From: [Mark Peacock](#)
To: [Planning](#)
Subject: FW: Hatfield. KFC Former De Haviland Building, Comet Way.16/1007/FUL, 1008/ADV, 1089/LB
Date: 06 August 2016 09:05:43

From: Andrew Robley
Sent: 05 August 2016 18:35
To: Mark Peacock
Subject: Hatfield. KFC Former De Haviland Building, Comet Way.16/1007/FUL, 1008/ADV, 1089/LB

drawing title
PROPOSED SITE PLAN

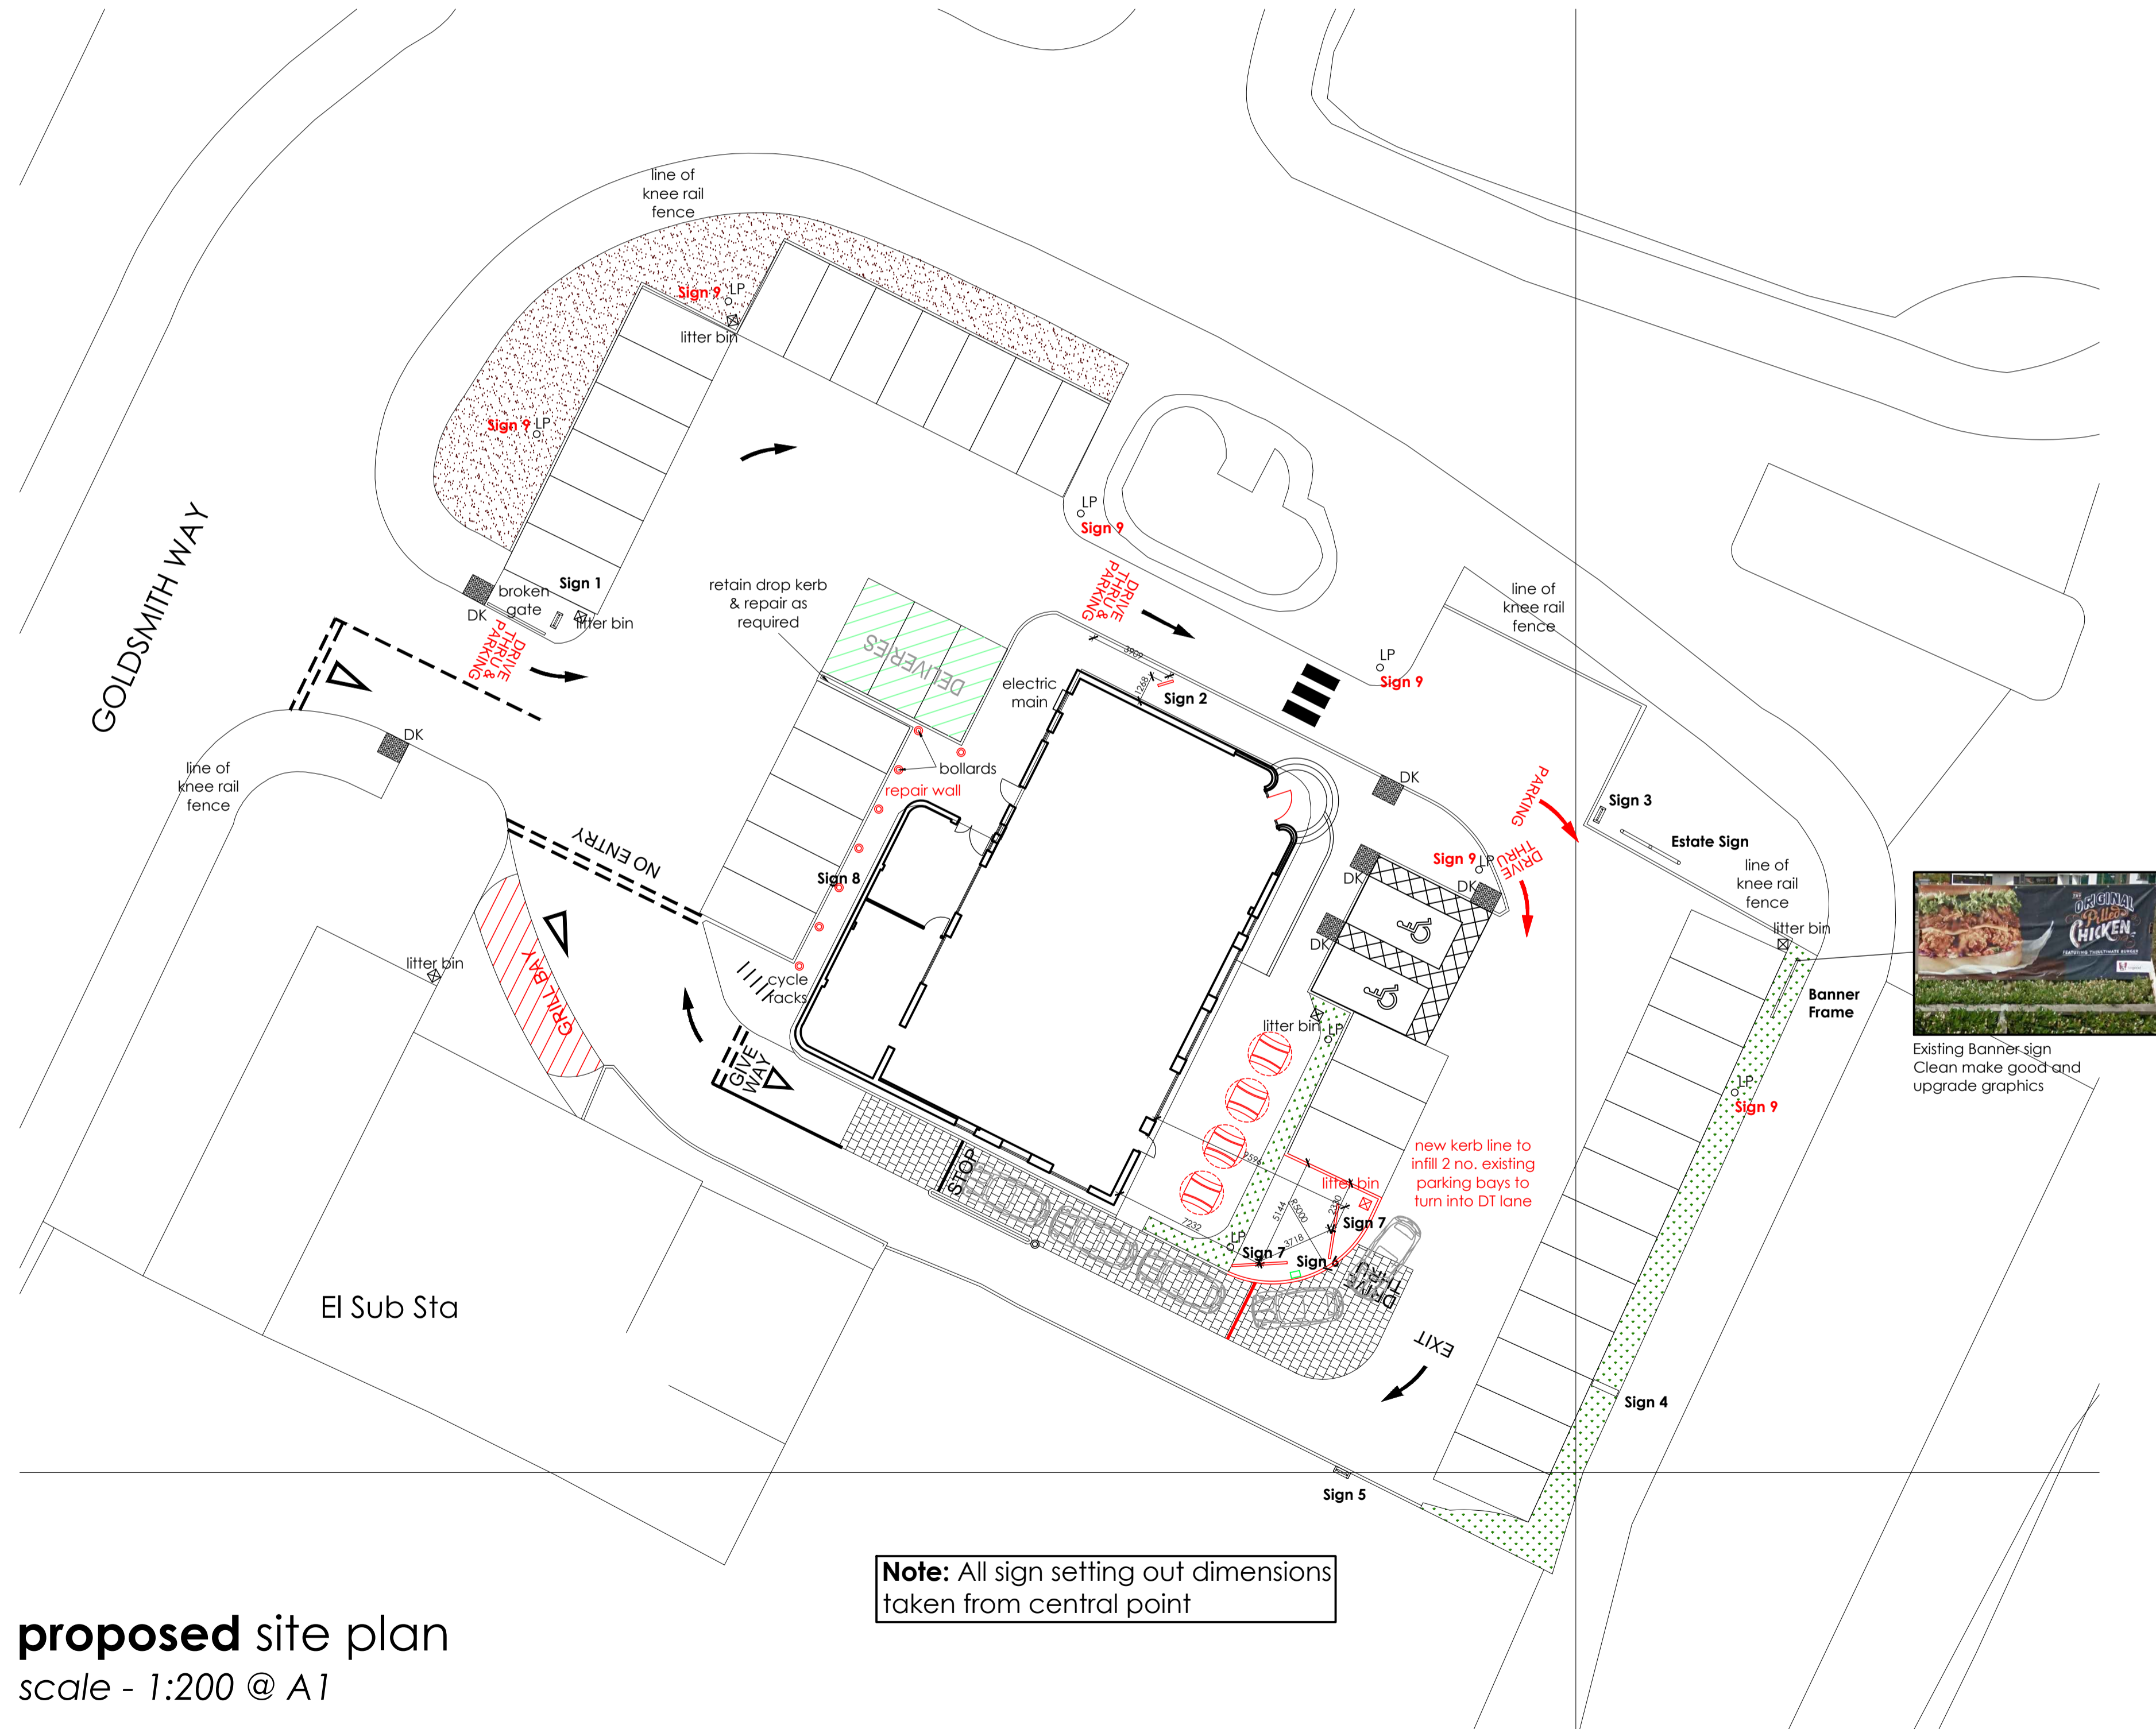
Sign 1-OK

Sign 2-This doorway sign at over 2 metres high would be very prominent and unacceptable.

Sign 3 –This is described as existing but I note that it does not appear on Google Streetview and so it may not have approval. If not, Unacceptable

Sign 4- This is existing and probably reasonable as the main warning for approaching drivers.

Sign 5- Relatively innocuous- OK

Sign 6- Sign 6 is the speaker post and necessary and acceptable

Sign 7 Pretty awful but presumably necessary. However, in this case better to retain in white rather than RAL 7022 due to relationship with the white building. 2 are shown. There should be only one and it should be at right angles to the front façade of the building.

Sign 8 Acceptable

Sign 9- These are multiple garish KFC signs on existing lighting columns. Unnecessary repetition and Unacceptable.

Estate Sign – Unnecessary and repetitious. People will be well aware that this is a KFC by the time they get to here.

Banner Sign – Hopefully this existing sign does not have prior planning consent- If not it is unacceptable and should be removed.

The new bollards should be simple but good quality and painted in the same green.
